Ribble Valley Borough Council
Housing & Development Control

Application no: **3/2023/0866**

Address: **Land adjacent to no 9 Old Road Chatburn BB7 4AB**

Proposal: **Proposed five-bedroom, two-storey dwelling with a room in the roofspace.**

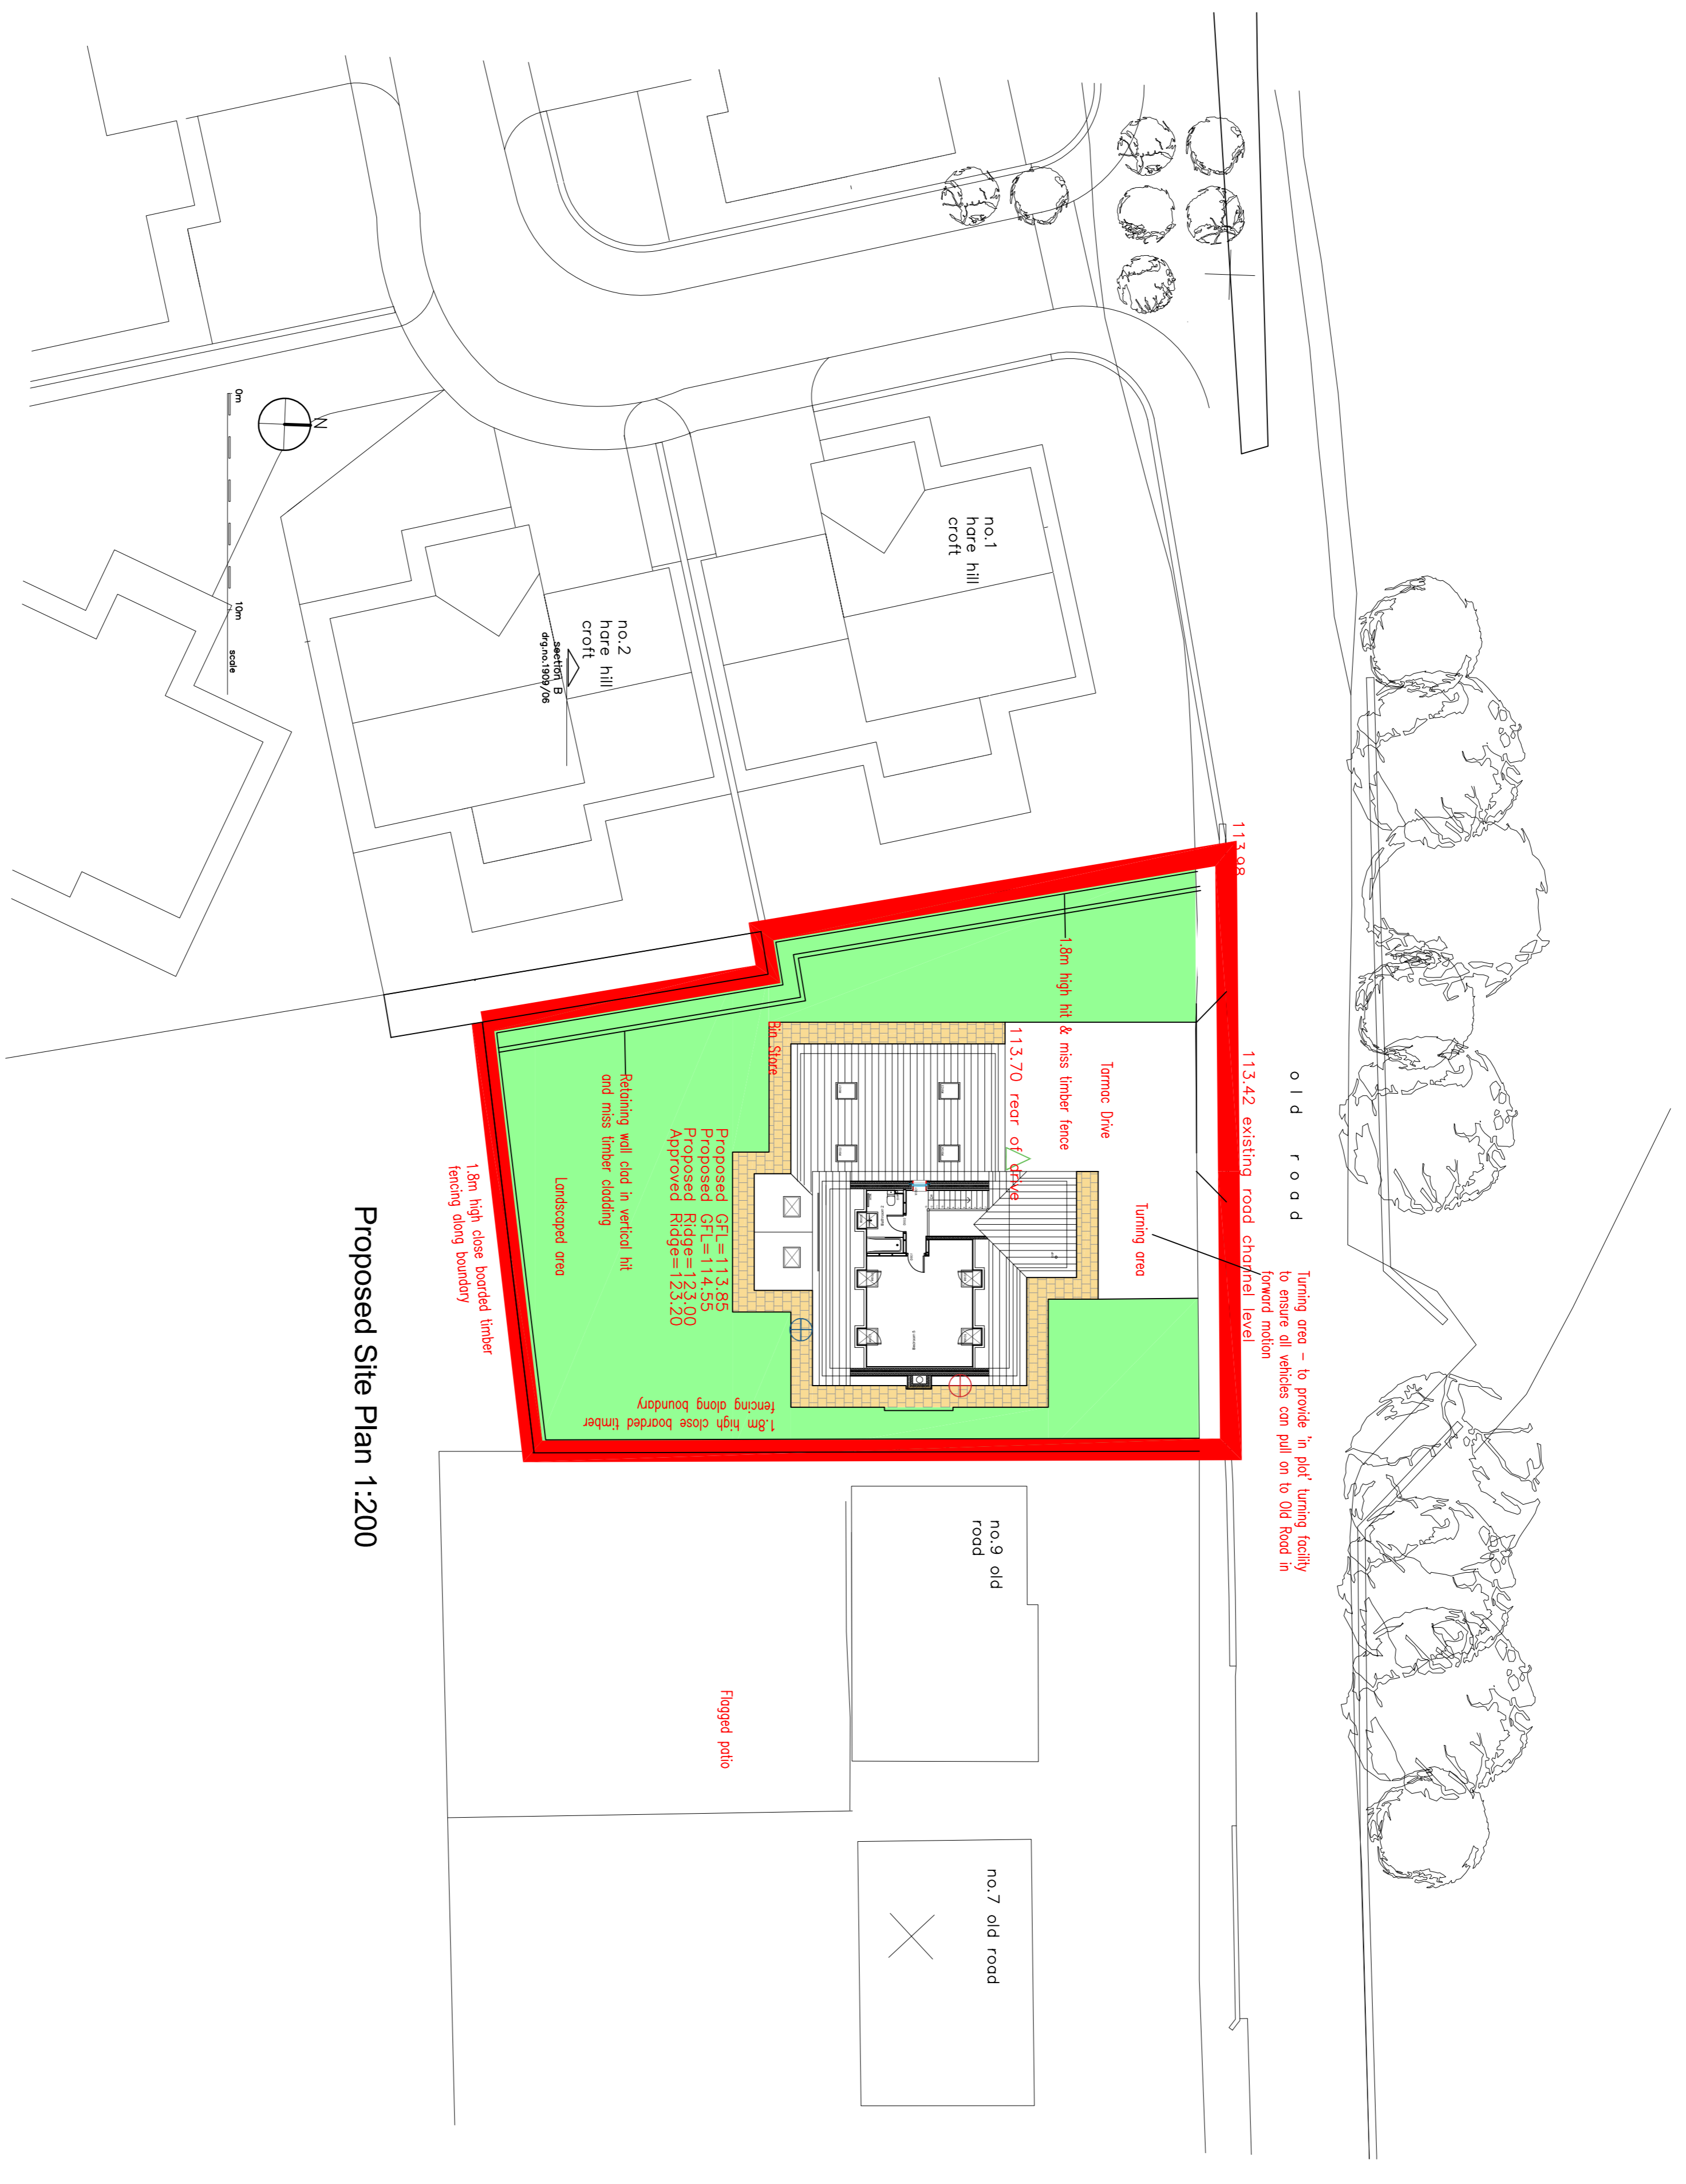
The LHA have reviewed drawing number COR/Plot 11/SP Rev A titled "Housetype Substitution Site Plan" and note that while the access width is acceptable when serving a single dwelling, the LHA require a visibility splay drawing to be submitted to support the application.

The LHA require visibility splays of 2m x 43m to be provided in both directions, given the posted speed limit of the adopted highway. Should the access not be able to achieve this, the LHA will require that the drawing shows what the maximum visibility splays will be. This is because the LHA are able to accept a shortfall in visibility, should the splays provided be greater than the splays which were accepted under application reference 3/2021/1153.

The LHA have reviewed drawing number COR/Plot 11/SP Rev A titled "Housetype Substitution Site Plan" and are aware that the parking arrangements complies with the LHAs parking guidance as defined within the Joint Lancashire Structure Plan.

The dwelling will also provide a minimum of one electric vehicle charging point and the LHA will later condition that a minimum of two bike stands are provided in the attached garage.

The LHA require a visibility splay drawing to be submitted showing the maximum visibility splays the access can achieve. Should the maximum splays be greater than the visibility splays which were accepted following application reference 3/2021/1153, then the LHA will have no objection to the proposal subject to conditions.
